**State Environmental Planning Policy (Infrastructure) 2007
State Significant Development Application – SSD-10473
270 Miller Street, North Sydney
Request for additional information**

270 Miller Street, North Sydney (SSD-10473)

PILES TO SOCKET INTO ROCK ABOVE SECOND RESERVE,
DO NOT EXTEND INTO SECOND RESERVE.

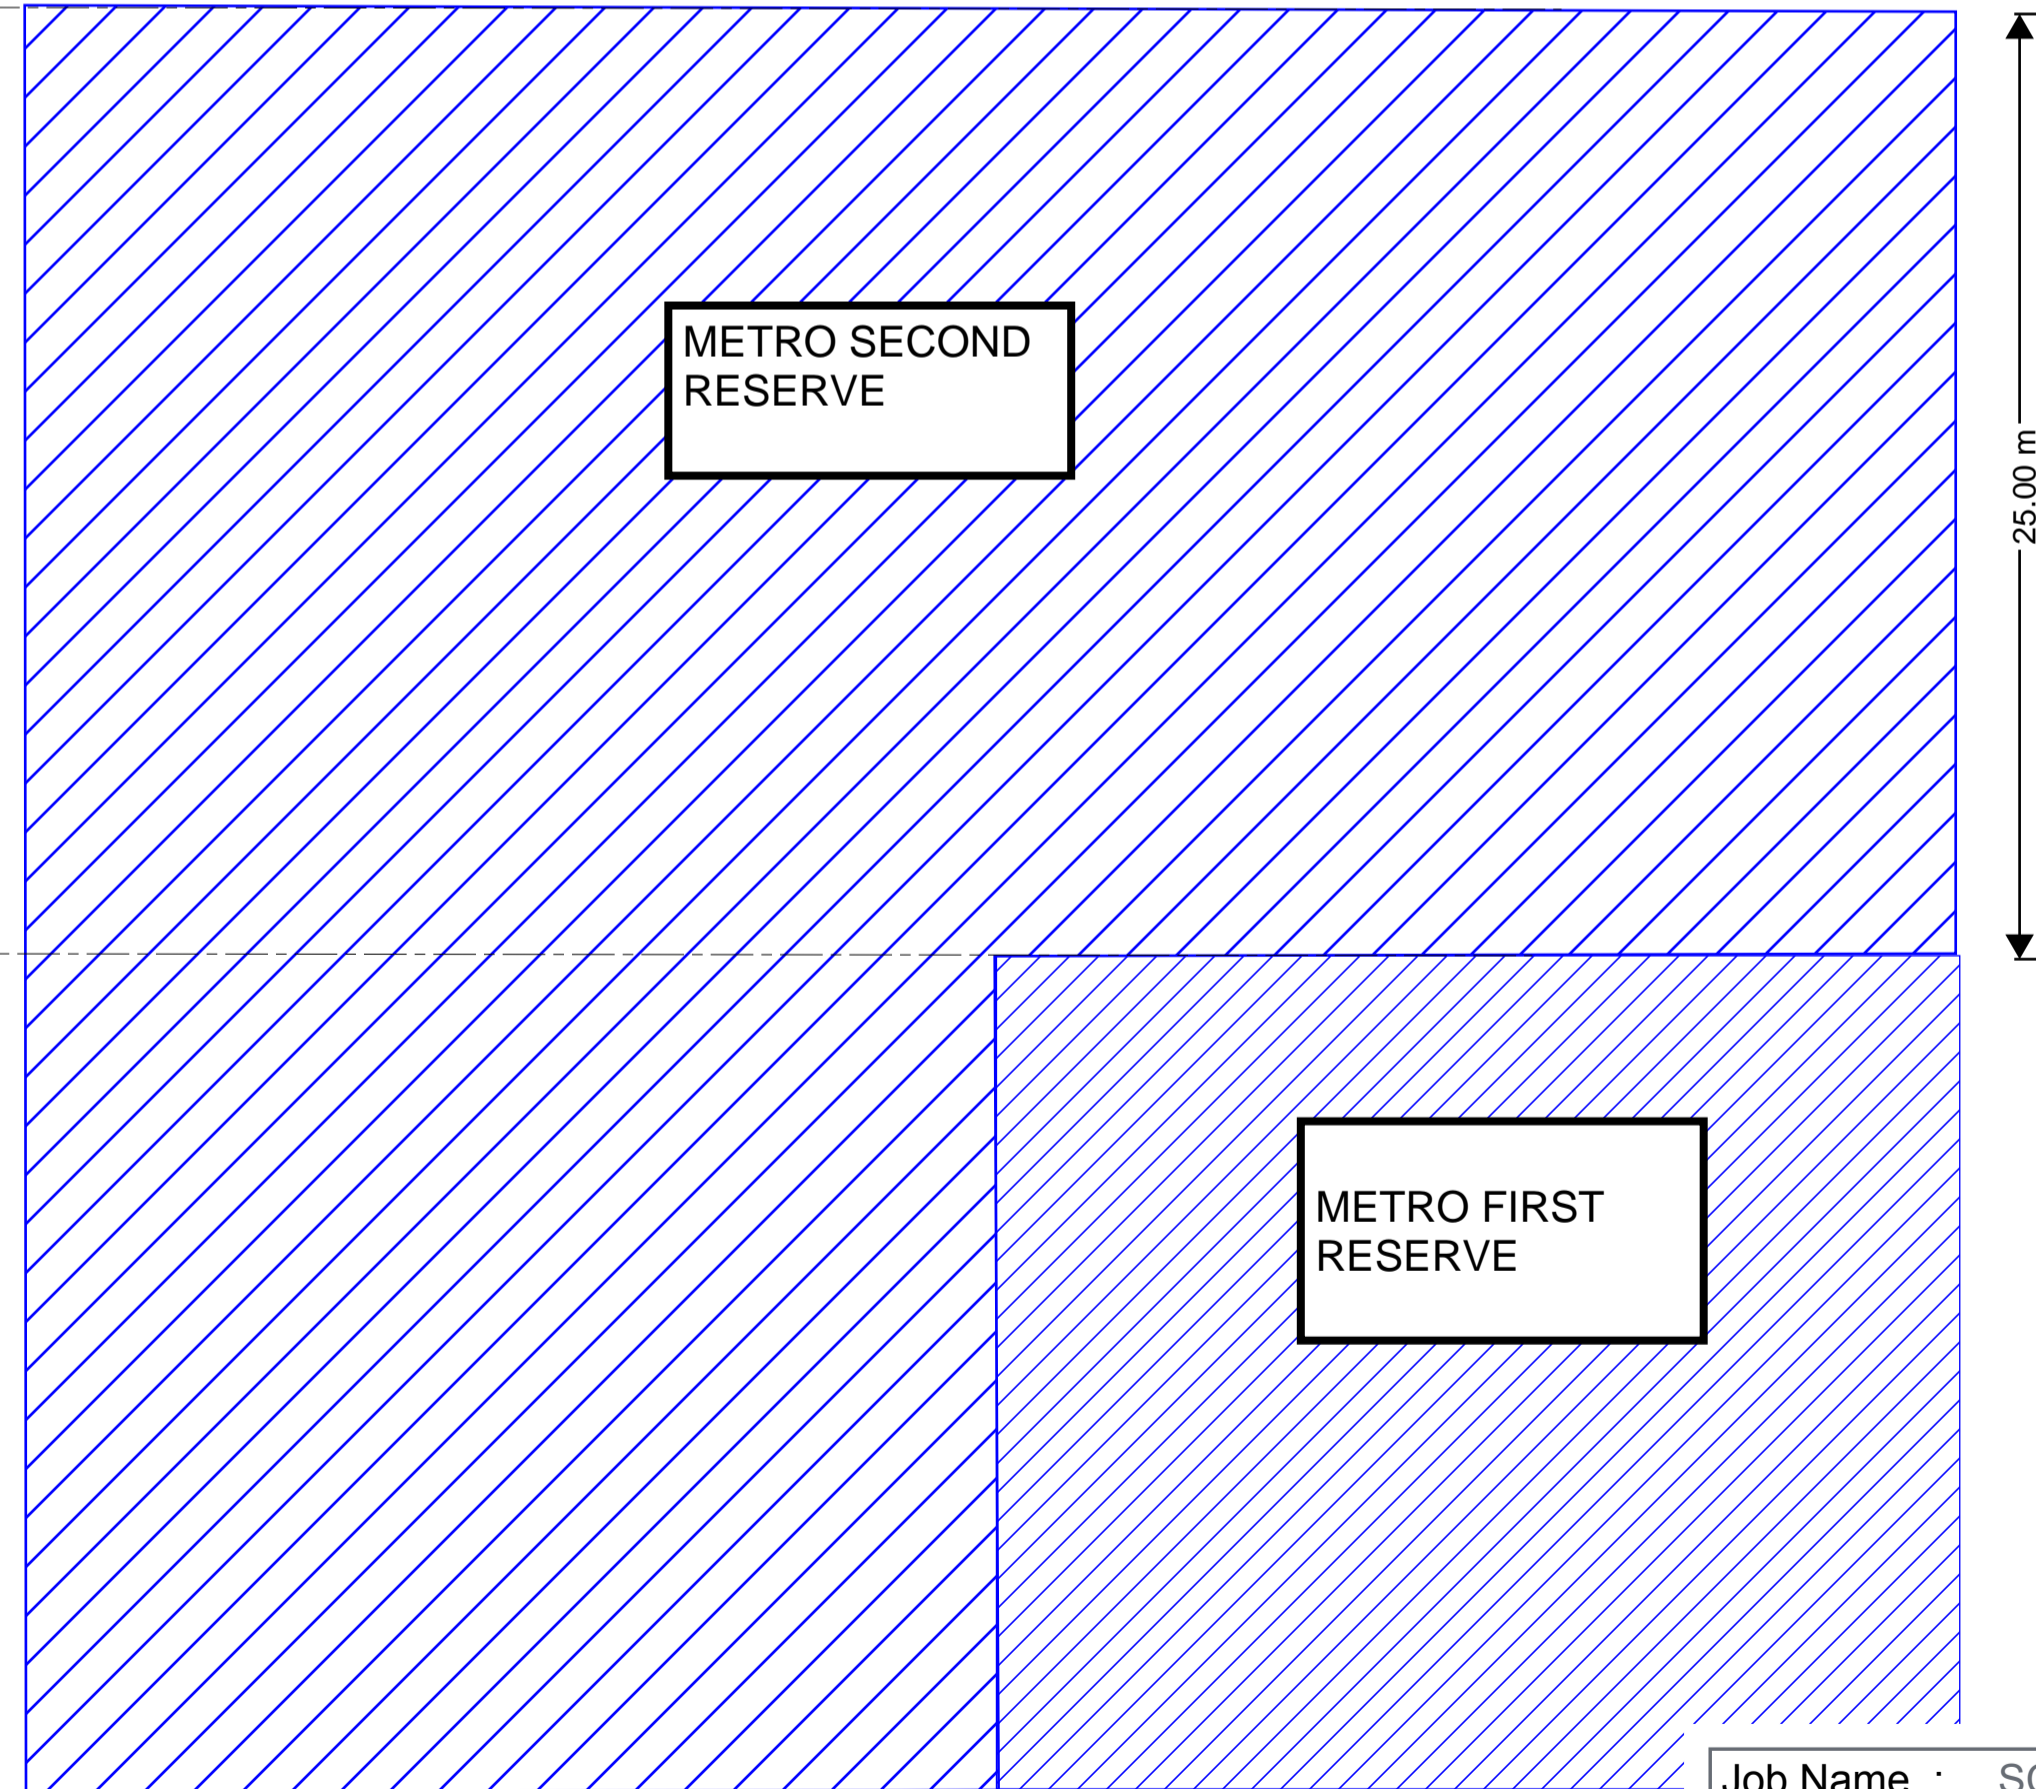
- a) The final design of pile foundation should be provided in order to confirm the risk levels on Sydney Metro infrastructure.
(together, Additional Information).
